**KIRKLEES METROPOLITAN COUNCIL
INVESTMENT & REGENERATION SERVICE**

Reference No:	2023/62/91803/W
Site Address:	410, Birkby Road, Birkby, Huddersfield, HD2 2DN
Description:	Erection of detached dwelling (modified proposal)
Recommending Officer:	John Holmes

DECISION – Conditional Full Permission

Officer Report – 2023/91803

project no.	drawing no.	revision
2165	04	A

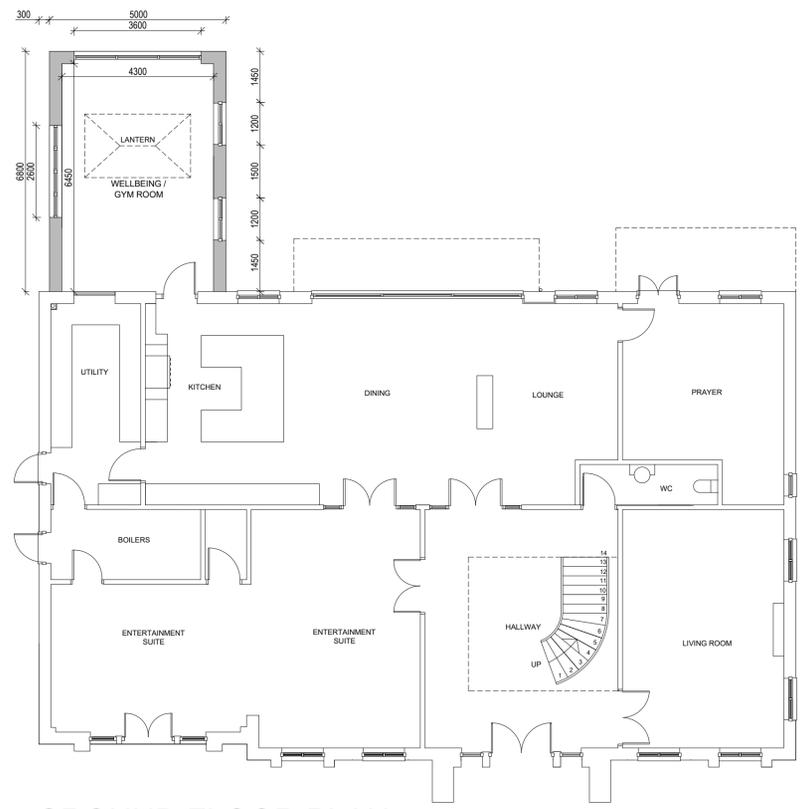
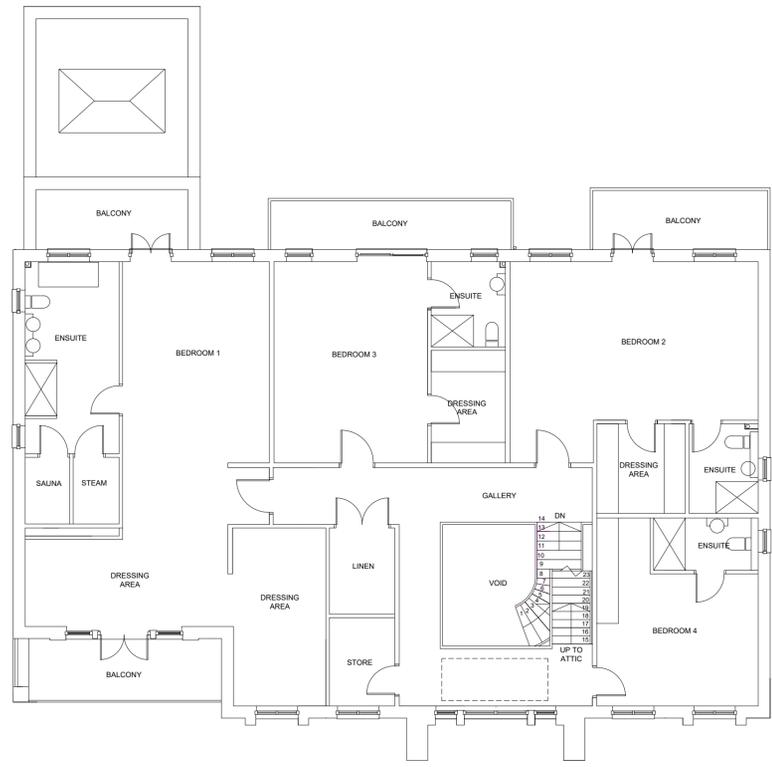
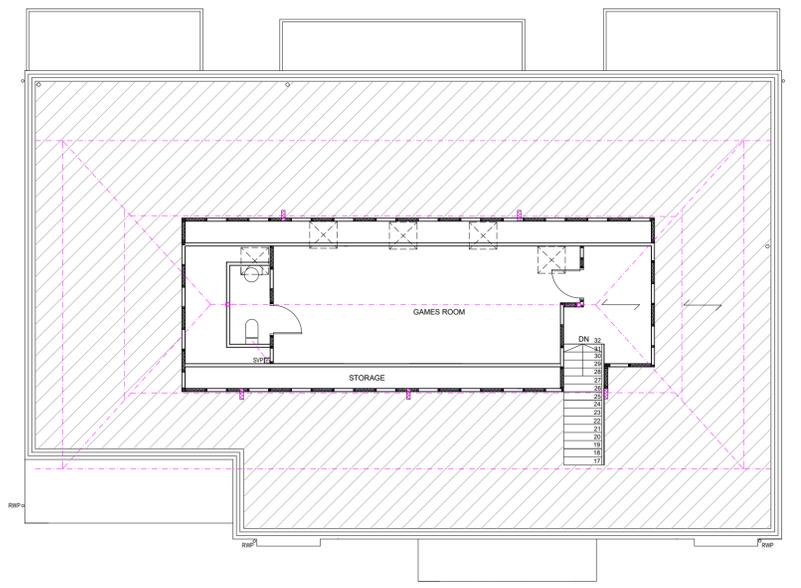
An updated drawing (ref: 04revA) has been submitted to show the entire dwelling which is proposed and also the floor plan layout. As set out in the submission, the amendment to the house-type for which permission is sought

relates to a single storey element to the rear which was shown on initially submitted drawing 04. As such it is considered that, whilst for clarity as to what is being considered, an updated drawing was requested / submitted, the scheme as publicised adequately alerted the public to the nature of the proposal.

A single storey element is proposed to the rear of the property, above which a balcony would be formed. It is considered that this element of the scheme, whilst of a visual parapet flat roof design, would not be out of character with the host property and is considered to be an acceptable design feature to the dwelling. It would not result in an overdevelopment of the site.

The additional single storey section to the rear of the dwelling features windows to the eastern and northern elevations and a high-level window to the western elevation facing no. 412. The eastern elevation of this section of the single storey element is considered to be sufficient distance from properties to the east of the site that no significant level of overlooking would occur from these openings, with these openings being approximately 30m from the eastern boundary of the site.

- The attached plans don't show the additional floor approved for no.410 on application 2022/92183

For clarity as to what is being considered, an updated plan which shows the amendment from the scheme approved by 2022/92183 and all elevations and floor plans approved by 2022/92183 has been submitted.

5. Prior to the first occupation of the hereby approved dwelling a 1.8 metre high obscurely glazed privacy screen shall be installed on the eastern side of the balcony that serves bedroom 2 and retained thereafter.
